Winterbourne Stoke Crossroads Early Bronze Age funerary complex: heritage and research significance and the impact of the A303 scheme proposals

Paul Garwood

1. Executive summary

Drawing Title
STRUCTURES DRAWINGS
WESTERN TUNNEL PORTAL
REGULATION 5(2)(o)
SHEET 8 OF 13

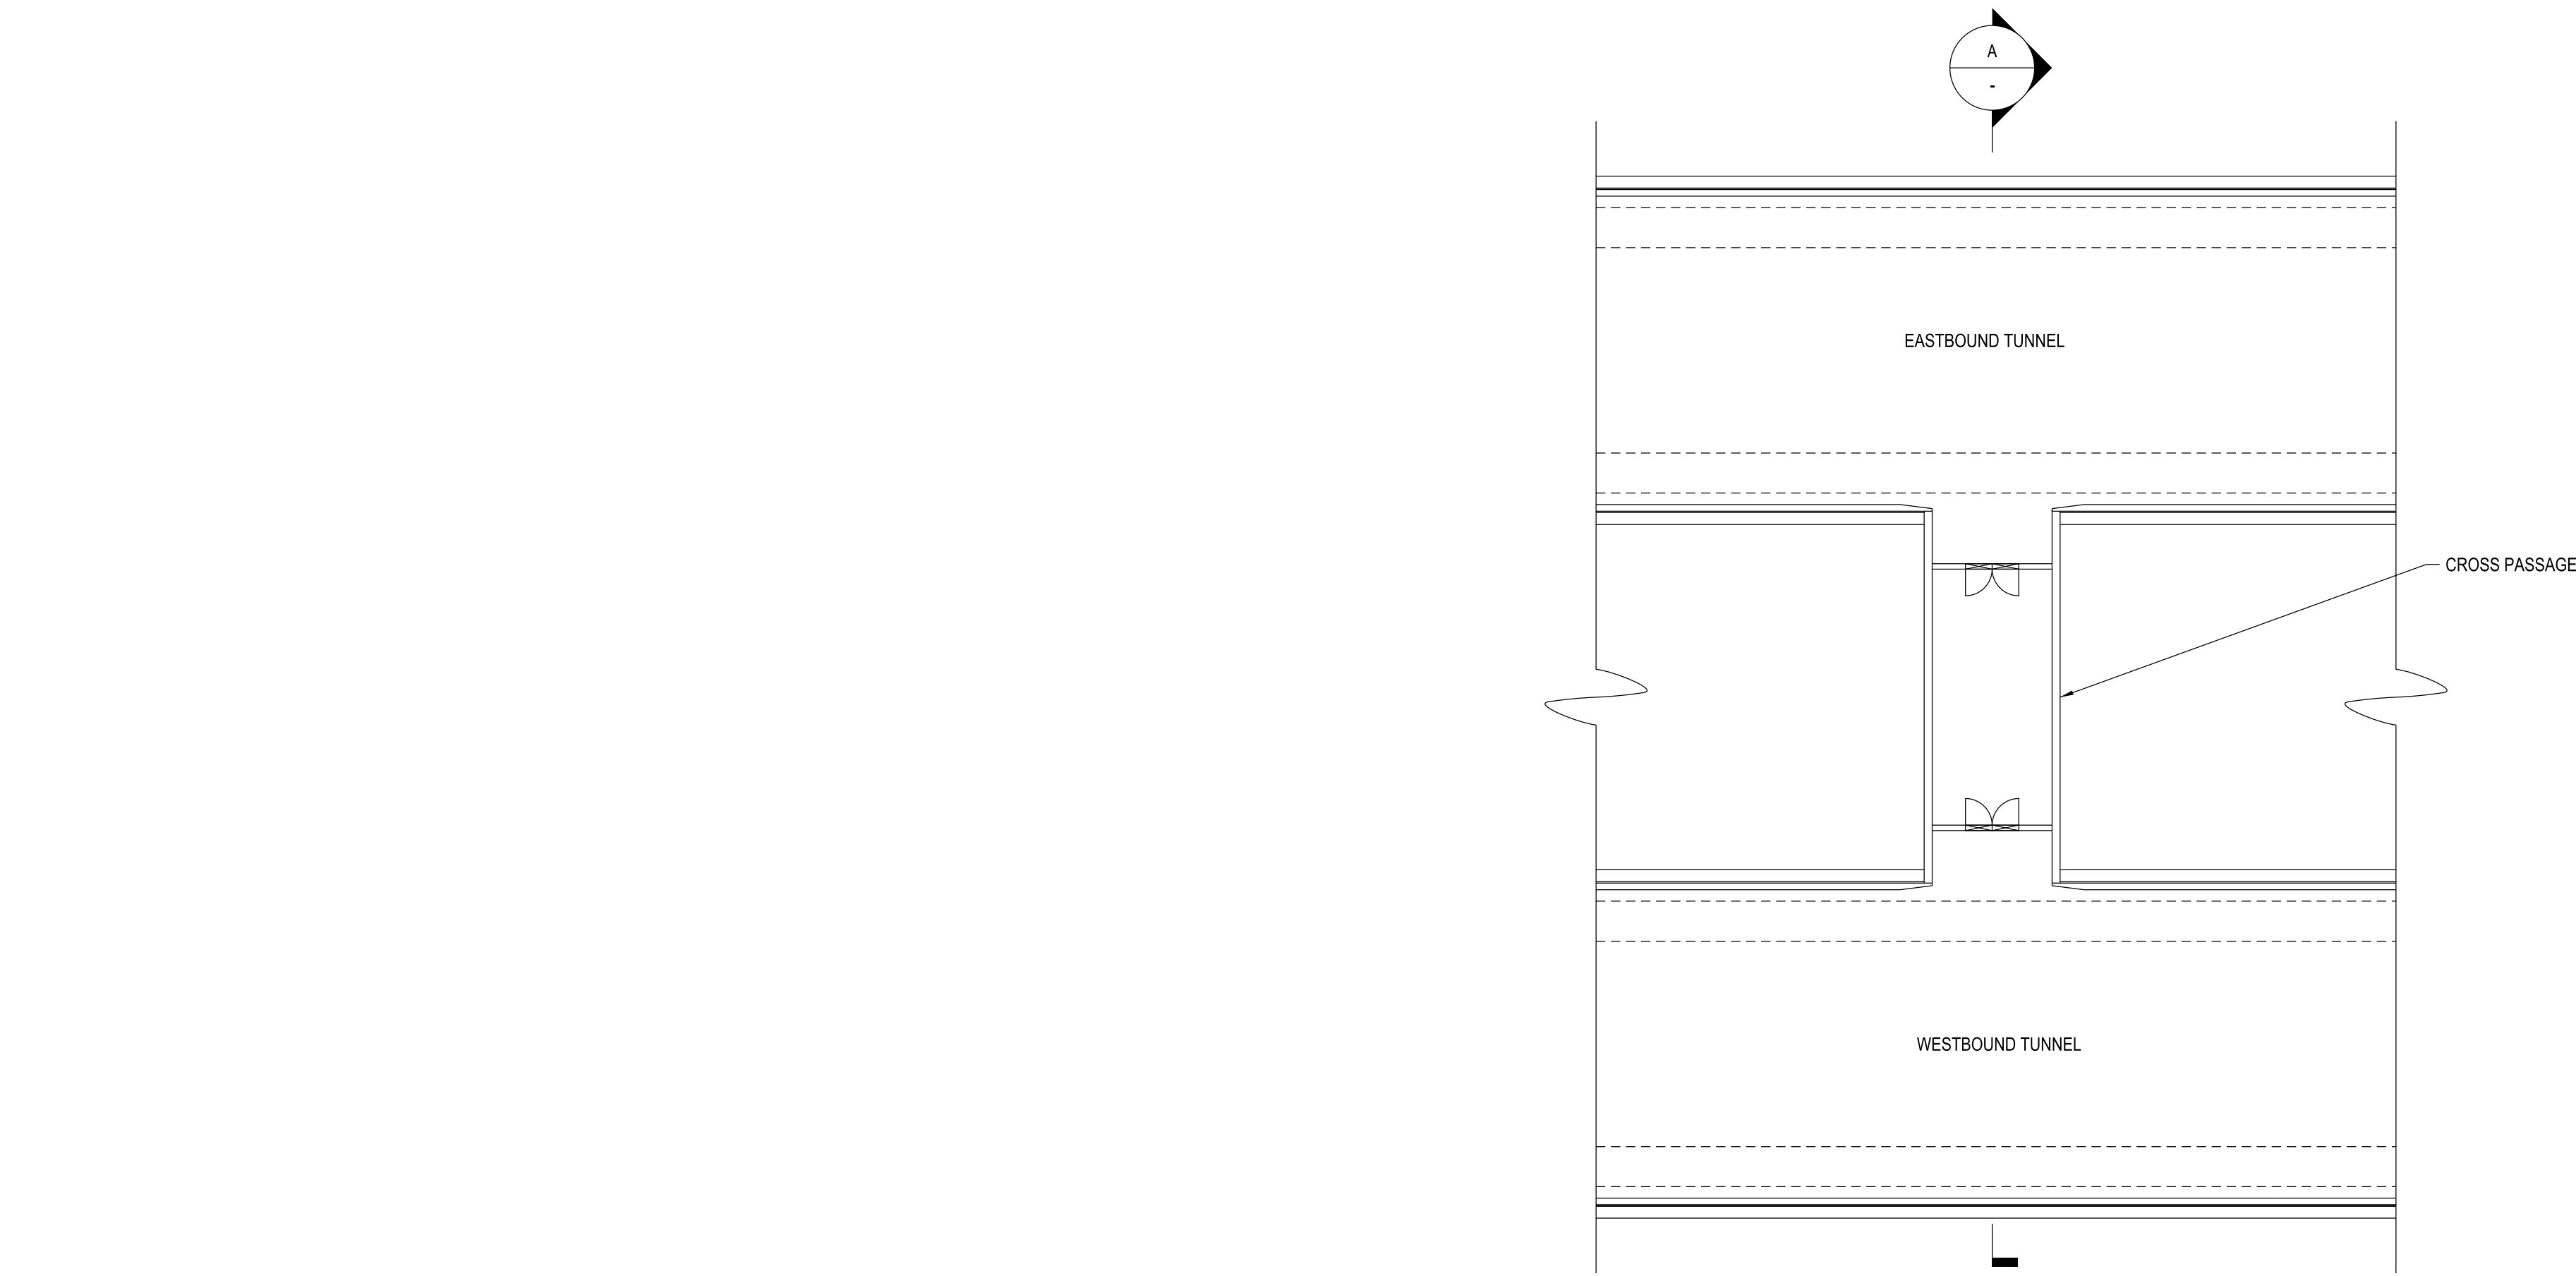
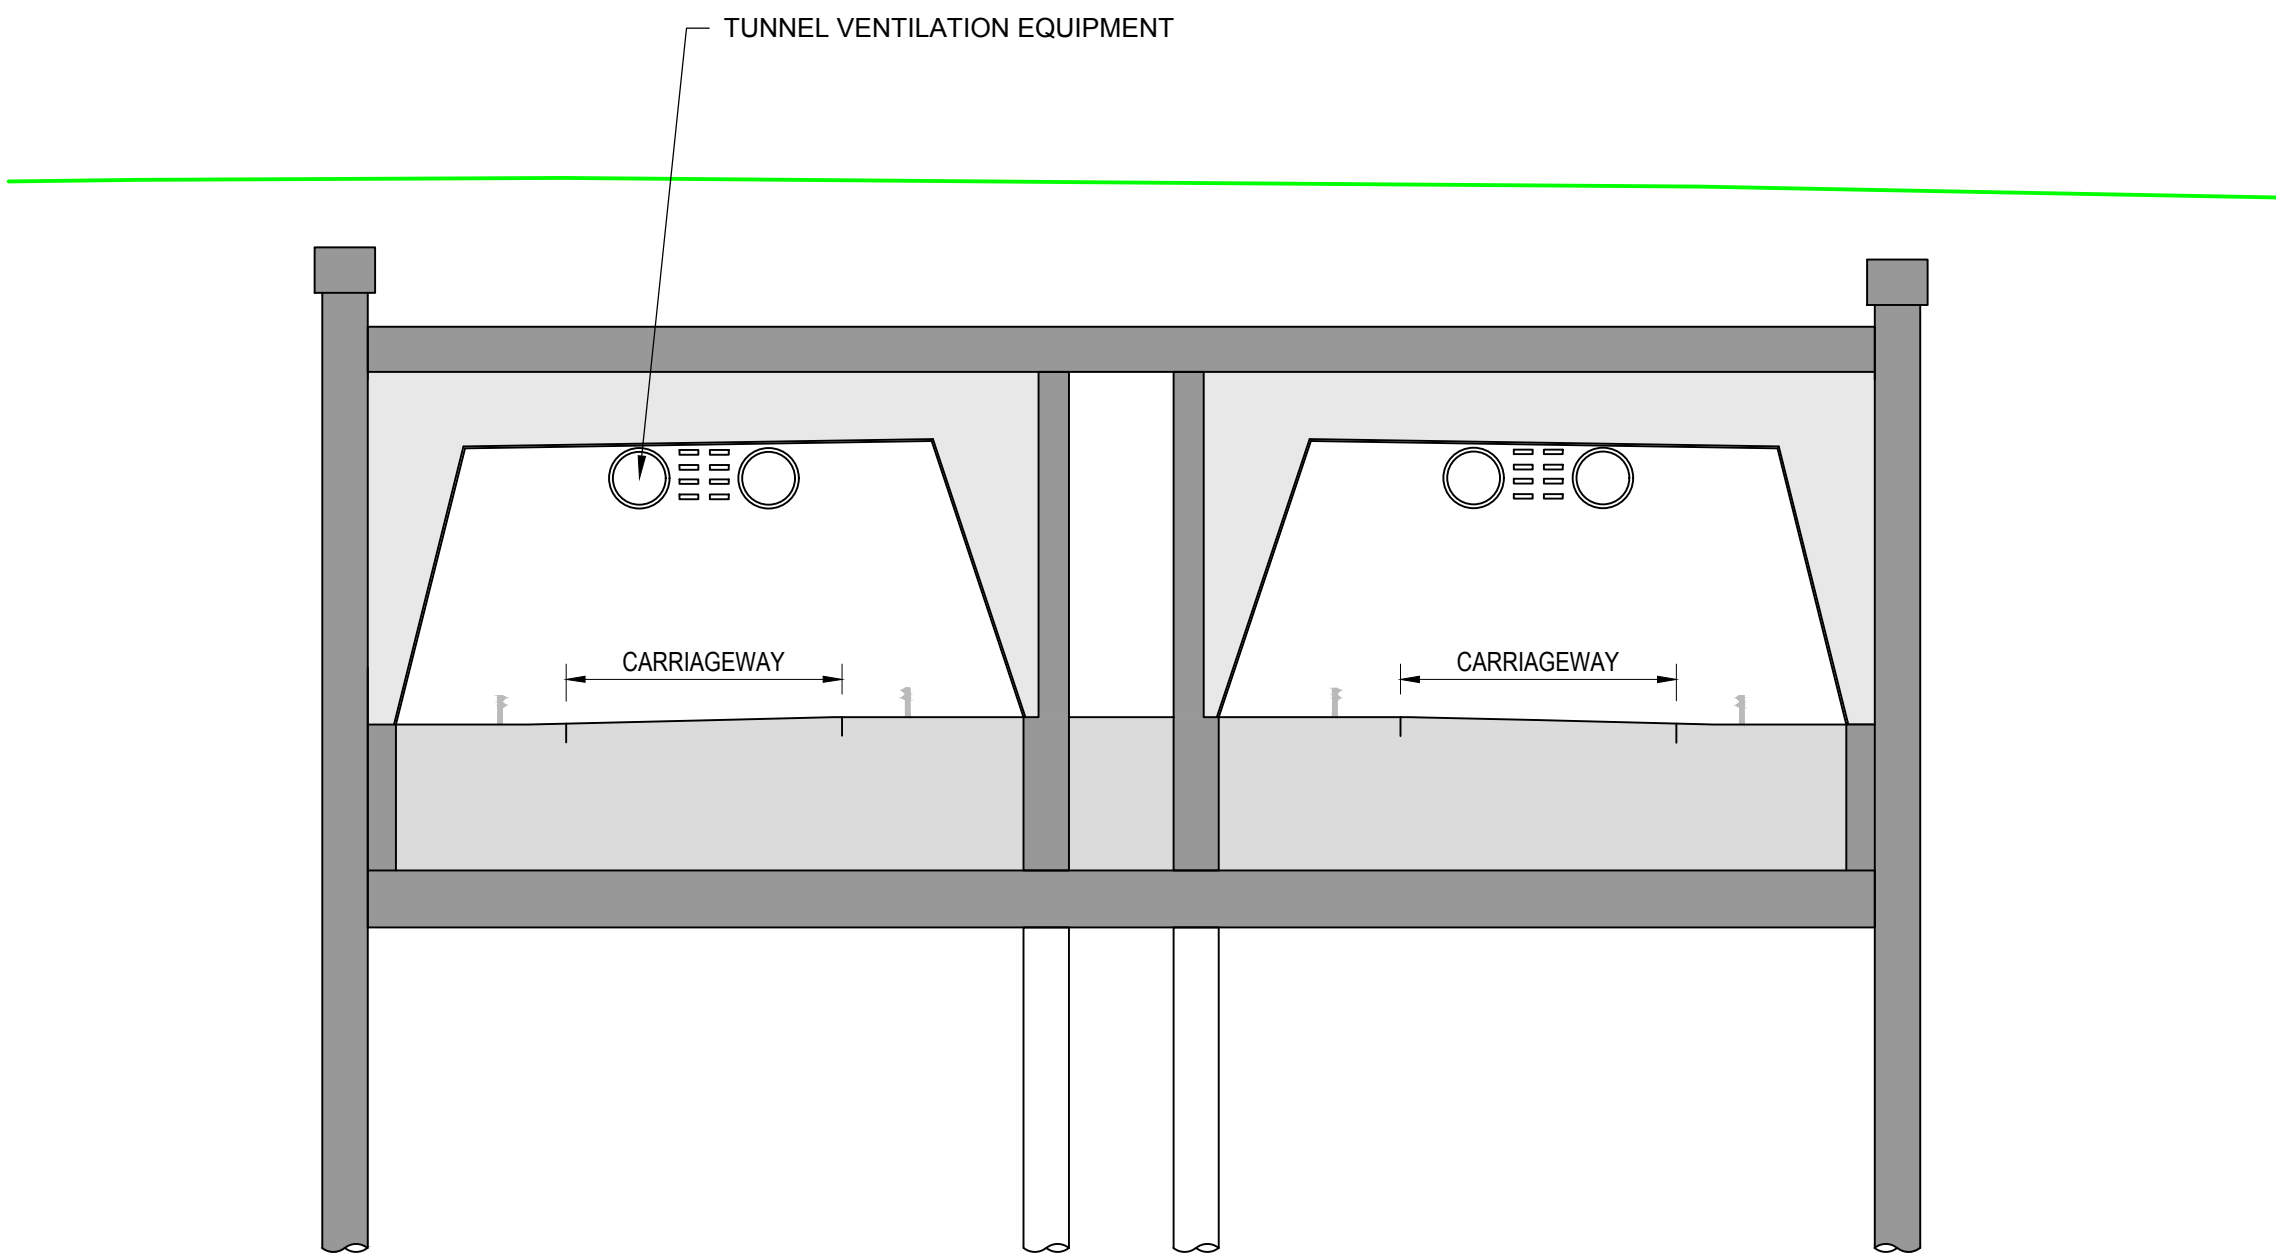
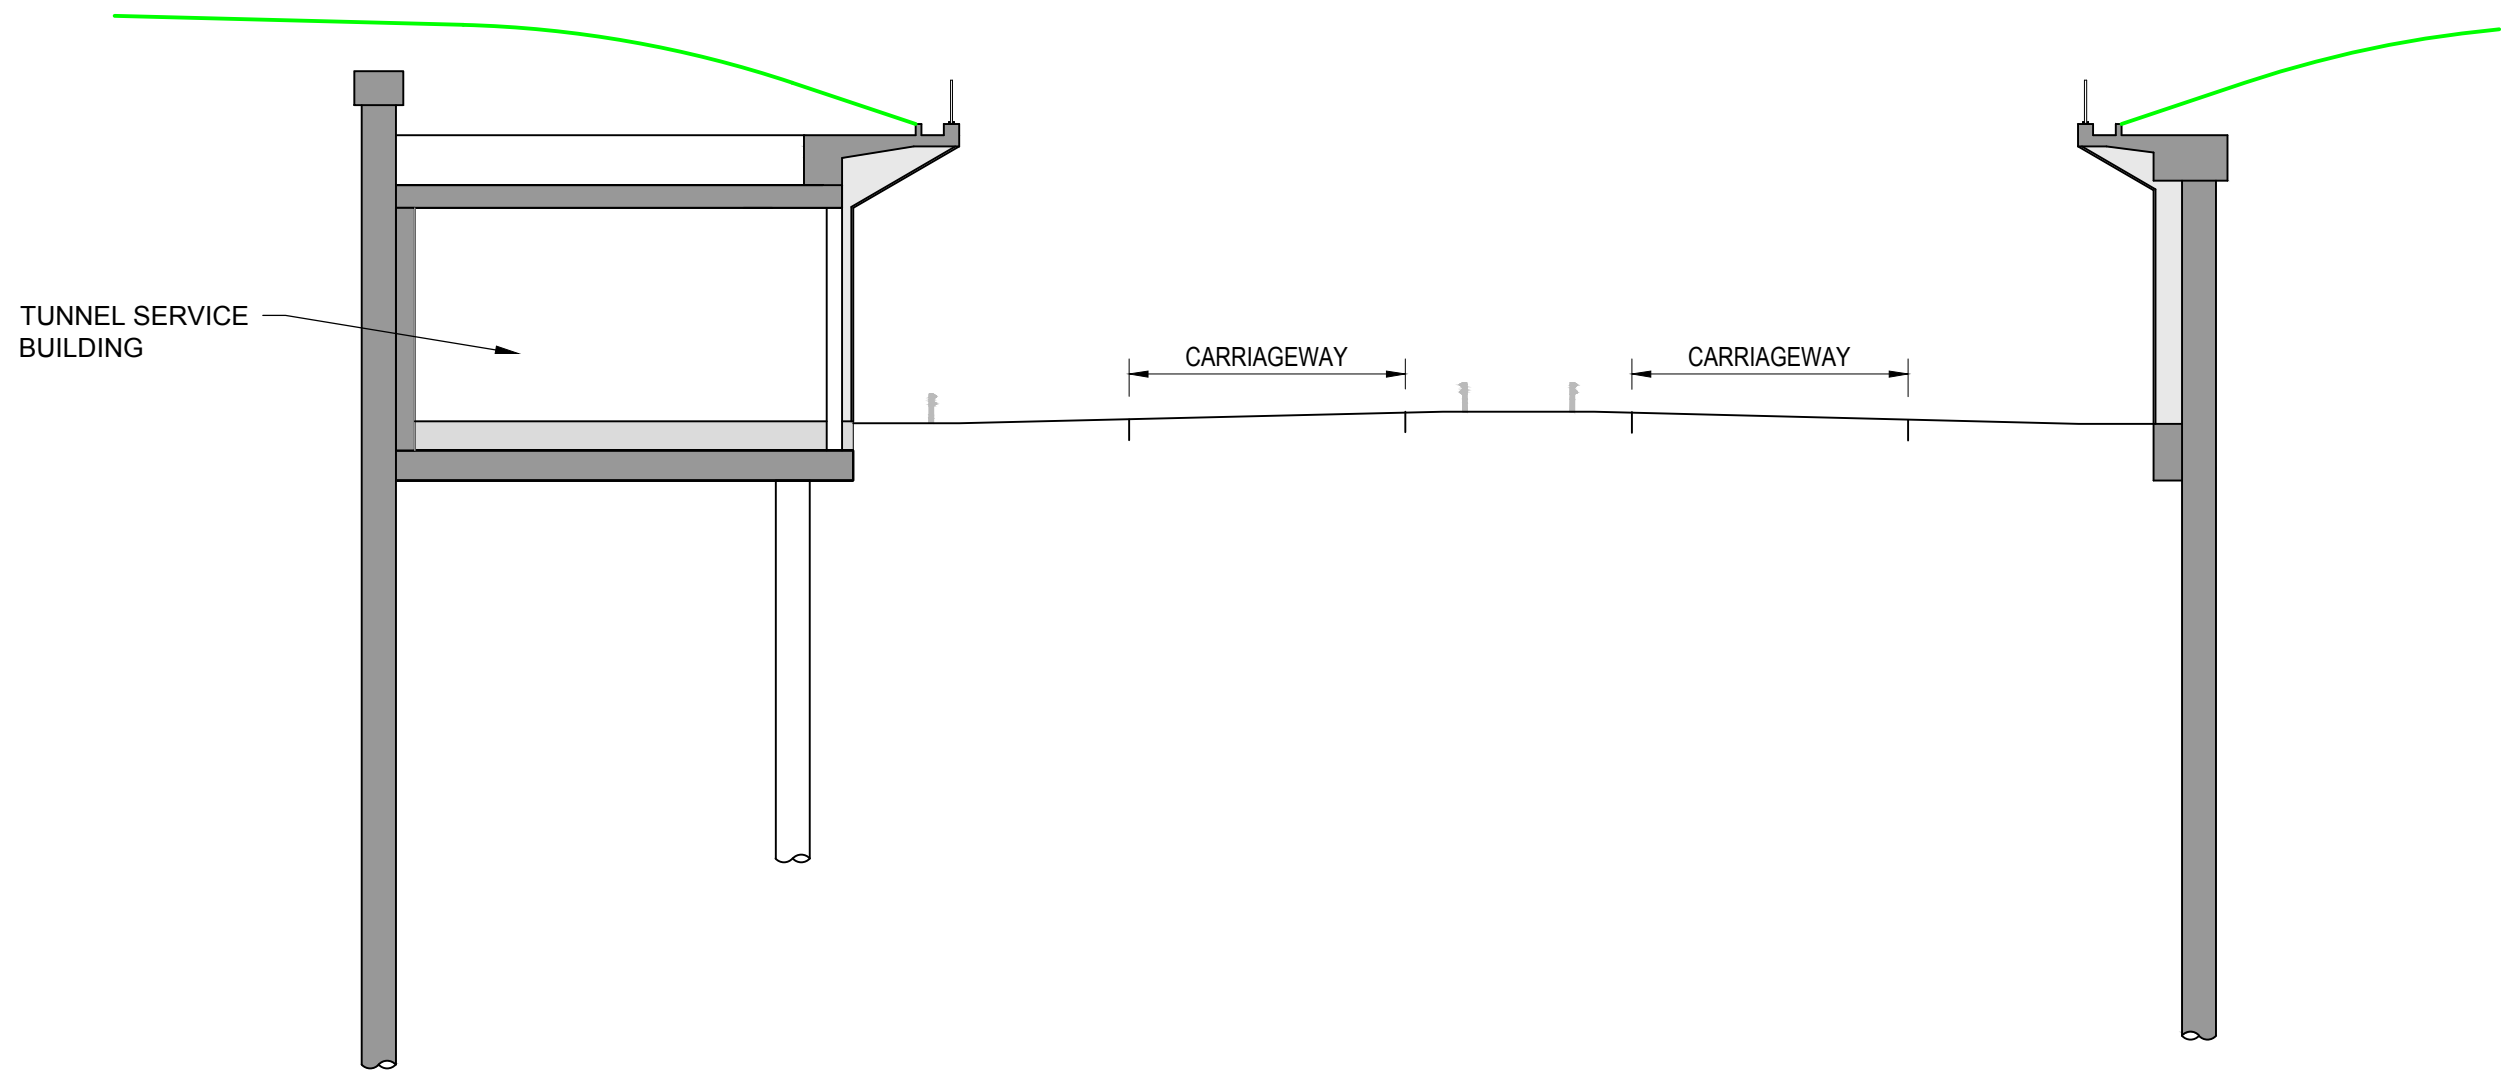
1.2. The proposal to keep the western tunnel portal and a greatly widened road for a kilometre within the WHS is out of keeping with both the UNESCO statement of Outstanding Universal Value (OUV) for the WHS (see Section 3) and current management and research strategies (see Section 4).

1.6. It is recommended that the western tunnel portal is moved at least 1.5 kms to the west (to a point outside the WHS). This will ensure that the integrity of the WHS landscape remains intact, that no destructive landscaping or carriageway construction takes place within the WHS, and that the setting of the Winterbourne Stoke Crossroads barrow group is not only preserved but enhanced to more fully reflect its unique character, importance for the OUV of the WHS, research significance, and future potential public benefits.

1. Should the Scheme be approved in any form, this should include moving the western tunnel portal at least 1.5 kms further west. This would ensure that the WHS landscape is kept intact and create a buffer zone outside the WHS to protect the visual setting and spatial integrity of the Early Bronze Age landscape, of which the Winterbourne Stoke Crossroads barrow group is such a significant part.
2. The setting and public presentation of the Winterbourne Stoke Crossroads barrow group should be enhanced to more fully reflect its unique character, research significance and importance for the OUV of the WHS.
